DECISION DELEGATED TO HEAD OF PLANNING

Application No: H14-0692-24 **Applicant:** Mr & Mrs S Pacey

Proposal: Replace existing boundary hedge & brick dwarf wall with new 1.837m high brick wall & piers

Location: 1 Primrose Crescent Pinchbeck Spalding

Proposed Elevations / Location / Block Plans

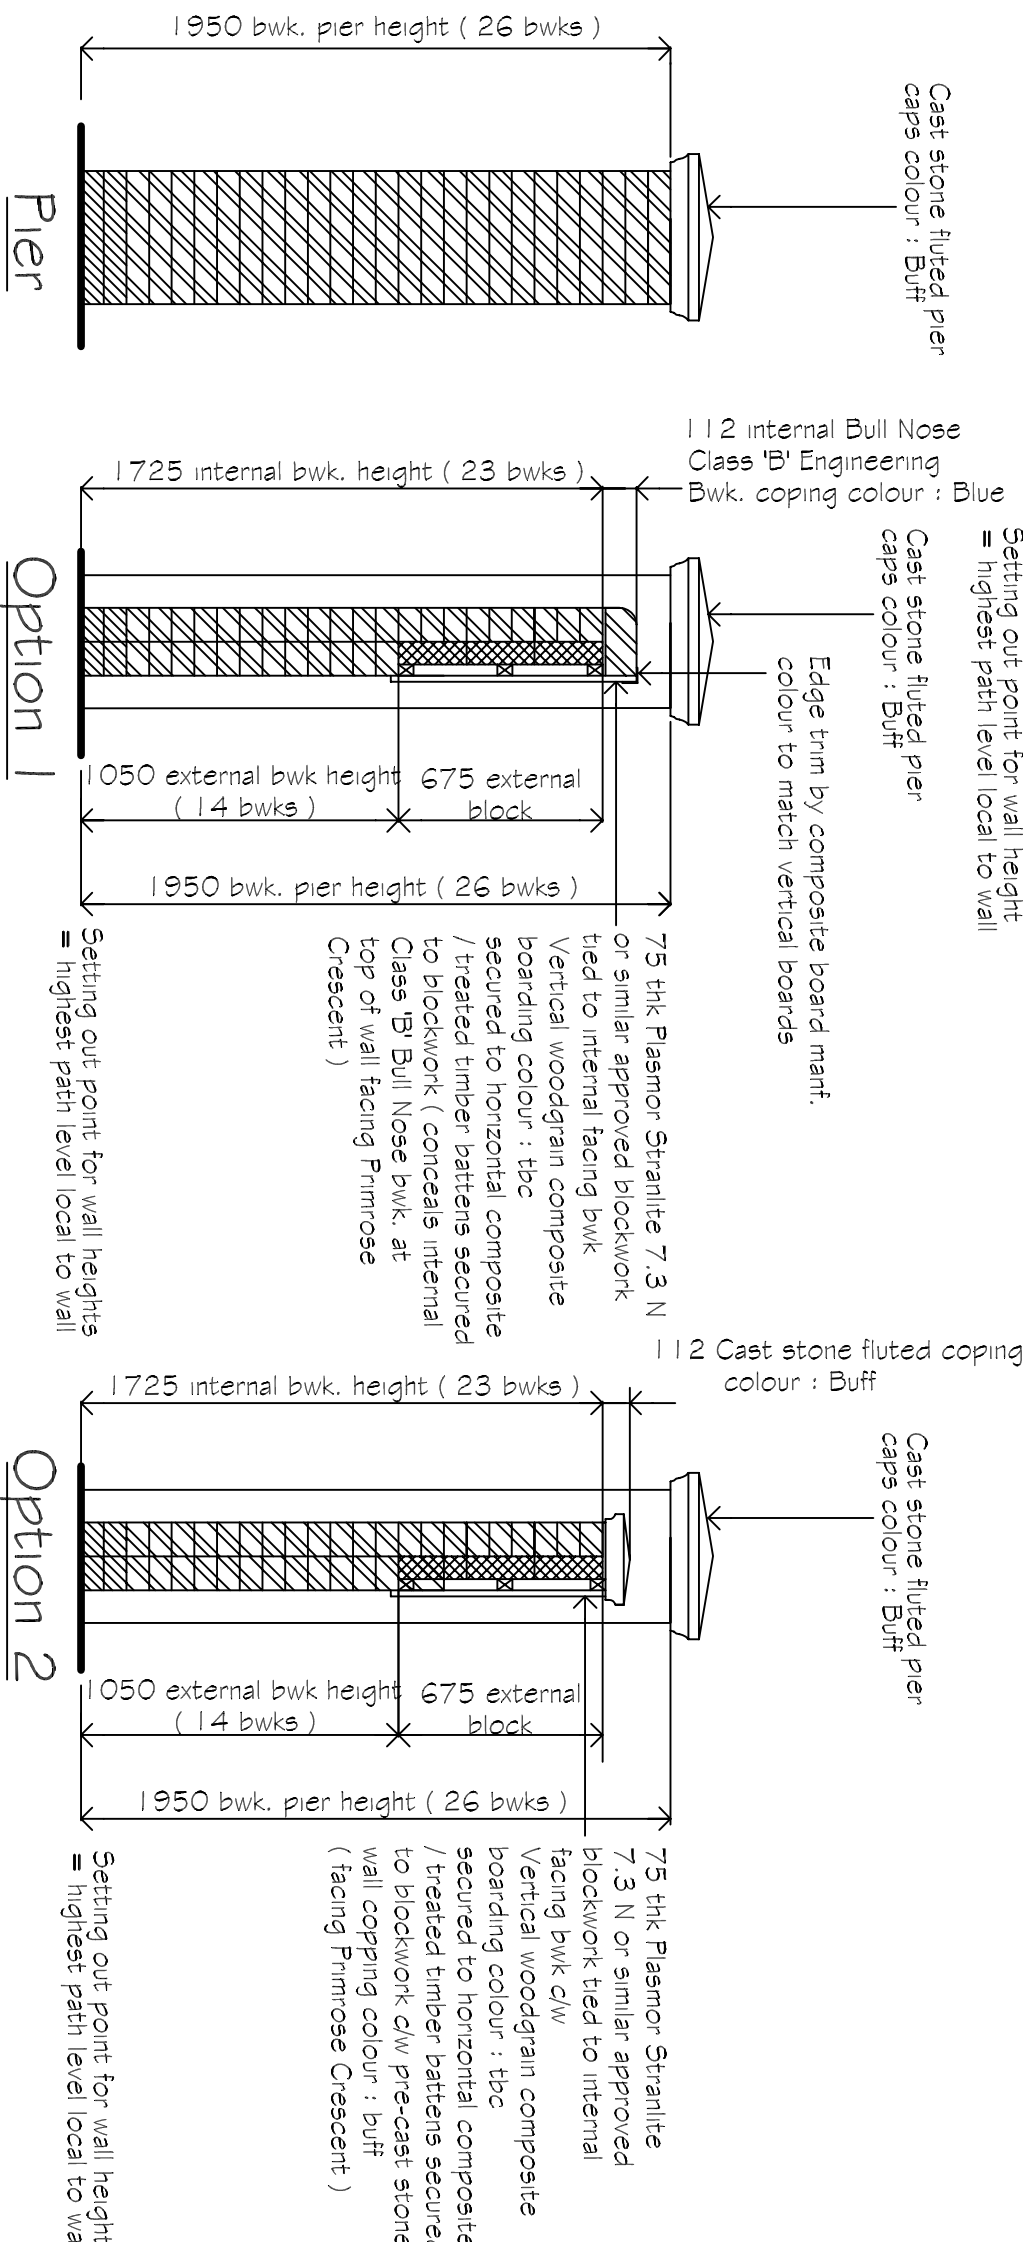
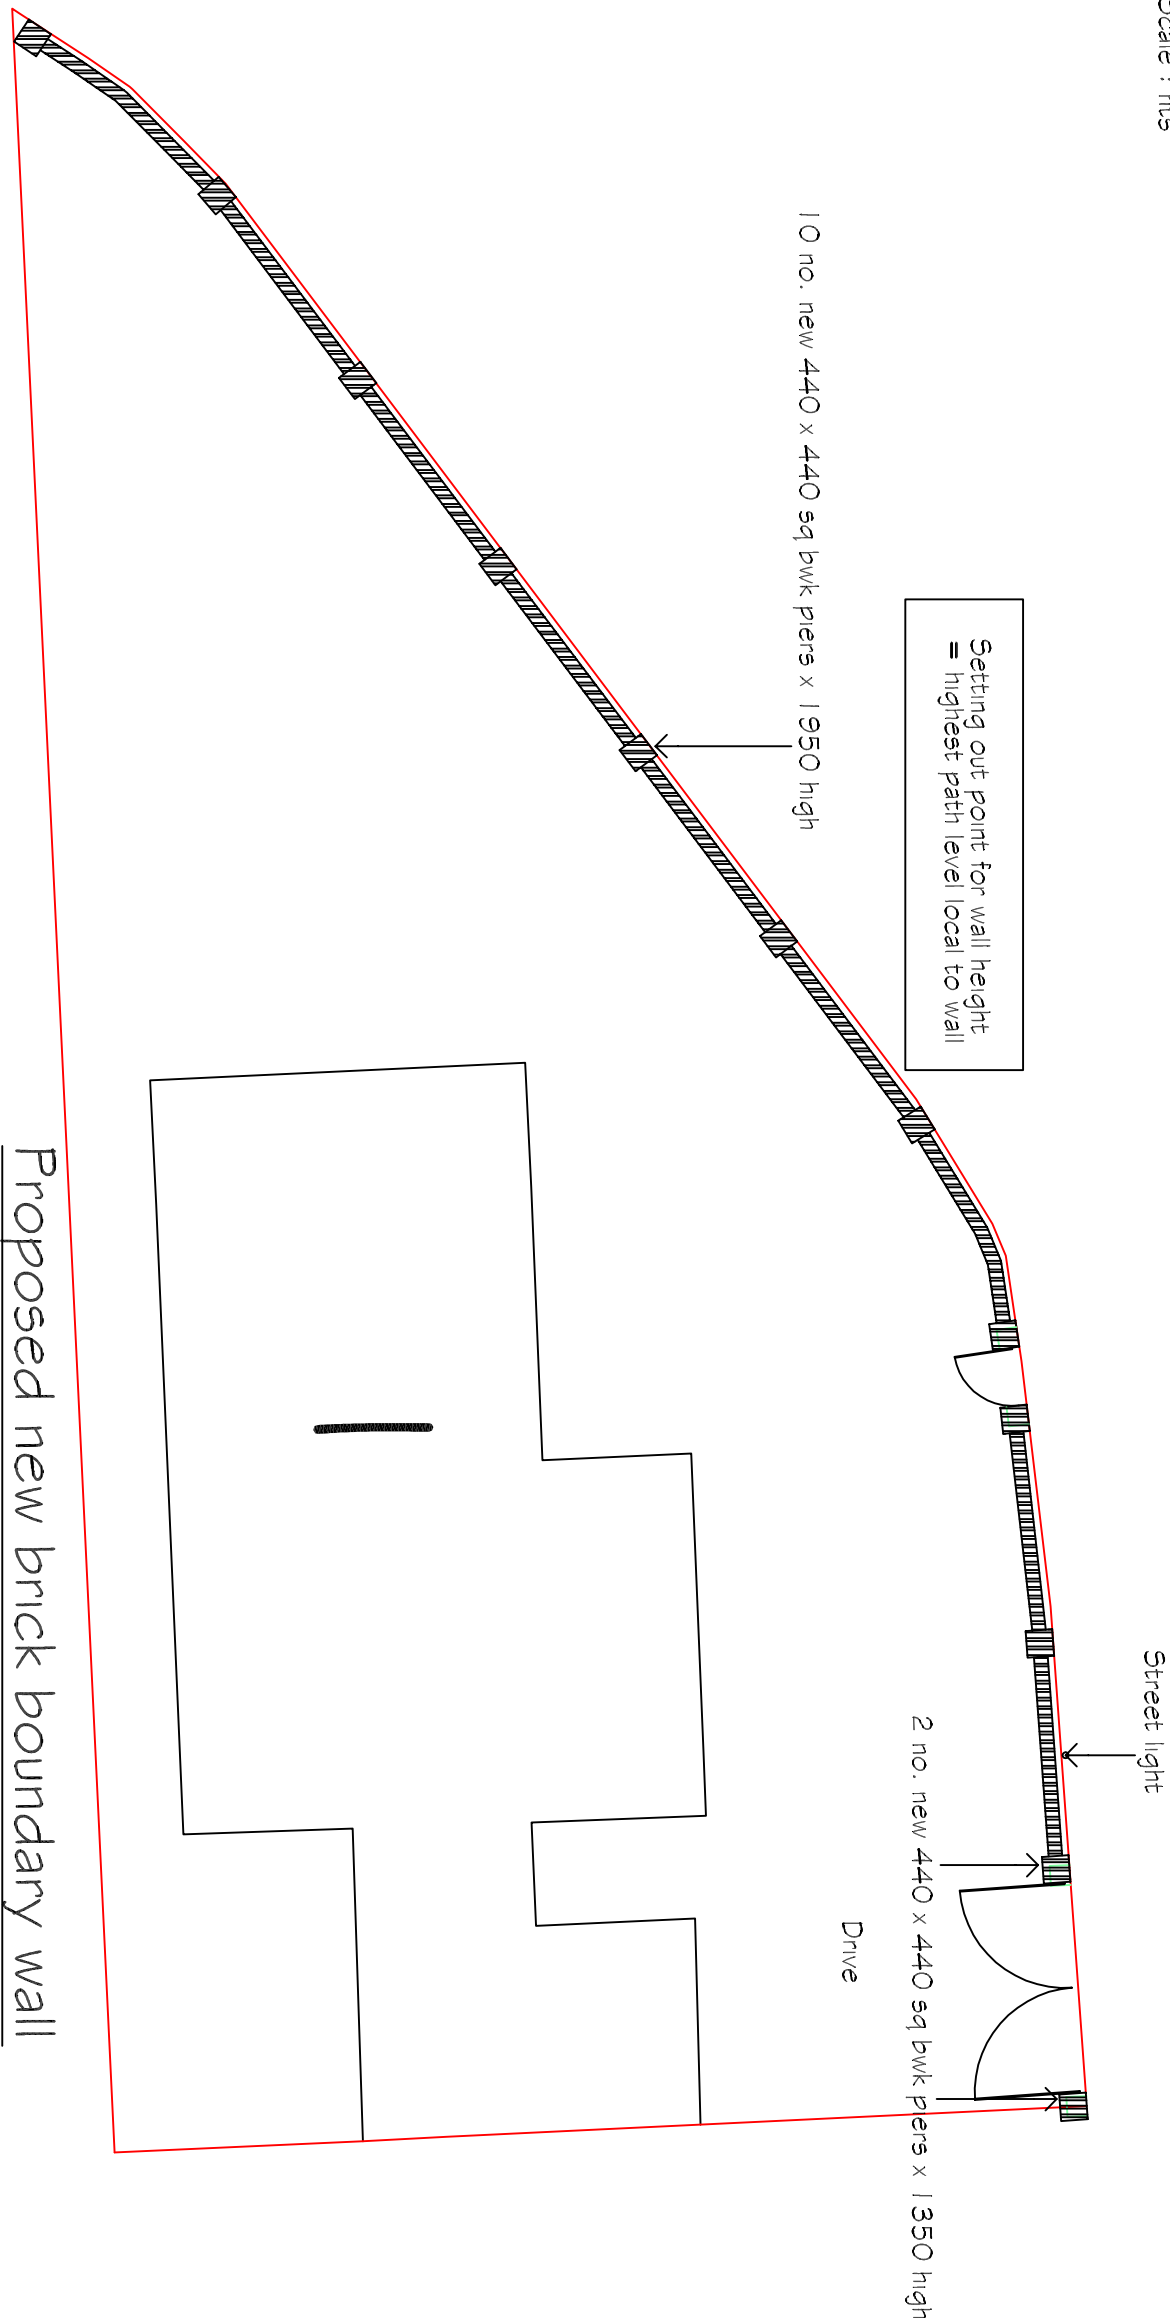
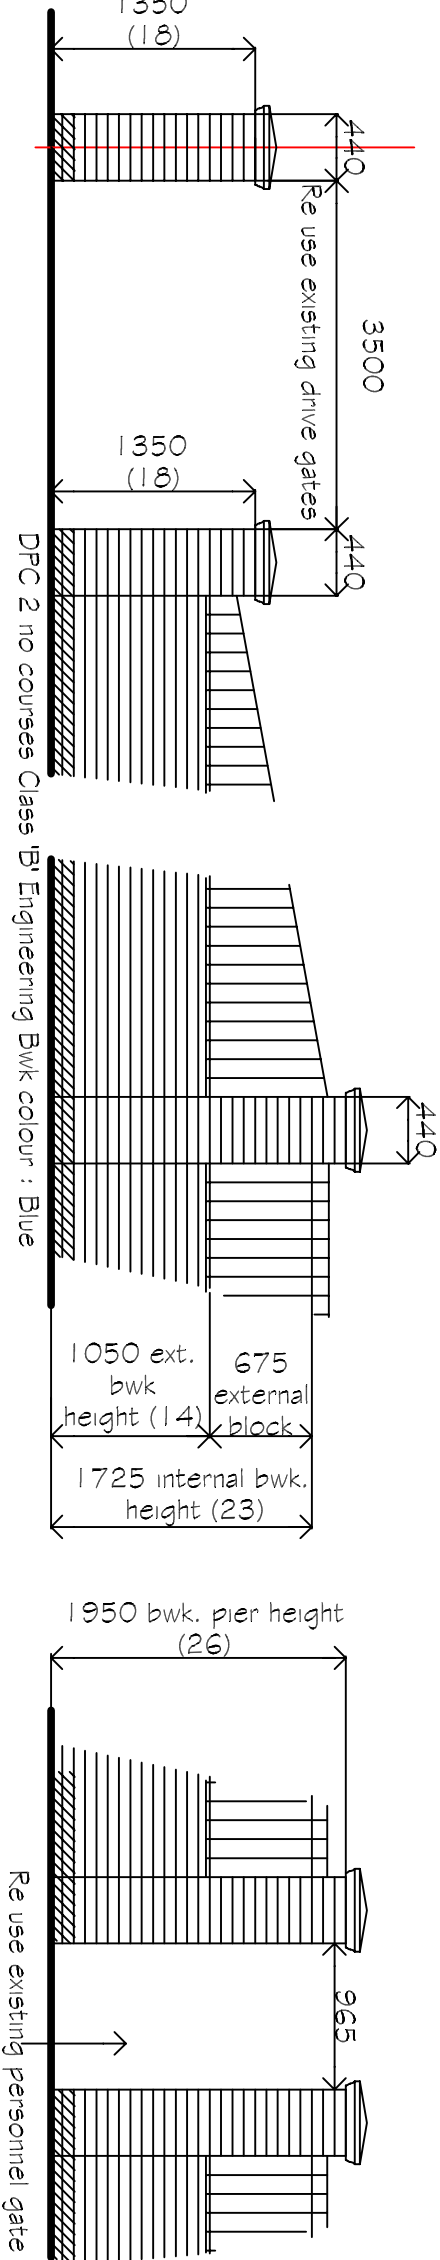
The proposal is similar in nature and scope to that of a previously refused application on site. The proposed boundary wall is to be 1.837m tall, proposing a modest reduction from that of the previously refused application of 273mm. Similarly, the proposed boundary wall would run the length of the external boundary of the host property, running the entirety of the application sites boundary with the highway of Primrose Crescent. This is as was previously proposed.

Whilst this would also be the to the extent of the existing wall and hedge, the proposed boundary treatment would comprise a height in excess of 1.8m. Notwithstanding the existing hedge, the proposed wall would provide an extensive bulk of brickwork running the entire length of this boundary, providing a much more stark and oppressive boundary treatment; with minimal openings as currently existing by way of a 3500mm gap for the driveway access, as well as the 965mm gap for the personnel gate.

It is considered that whilst the proposal has sought to amend the height, by proposing a reduction to the height of the wall when viewed alongside that previously refused, the resultant proposal, as currently submitted within this application, will remain an oppressive addition, and would adversely harm the character and appearance of the area.

In light of this, it is considered that the proposed boundary wall would have a notable adverse impact upon the street scene, surrounding character and locality due to its scale, extent, the prominence of the site and its proximity to the footpath.

It is noted that the current boundary treatment, in the form of a dwarf wall and hedging, a much increased natural boundary, provides screening to the site and as such, this aim is already established at the site in its current form. The extent of boundary wall, within the prominent location and proximity to the footpath, is not considered to be suitable and is considered to cause an unacceptable harm to the character and appearance of the area.

Taking account of the design, scale and nature of the development, as detailed above, the proposal is considered to be unacceptable. The proposal would cause an adverse impact to the character and appearance of the area and would therefore be in conflict with policies 2 and 3 of the South East Lincolnshire Local Plan and Section 12 of the National Planning Policy Framework (December 2023).
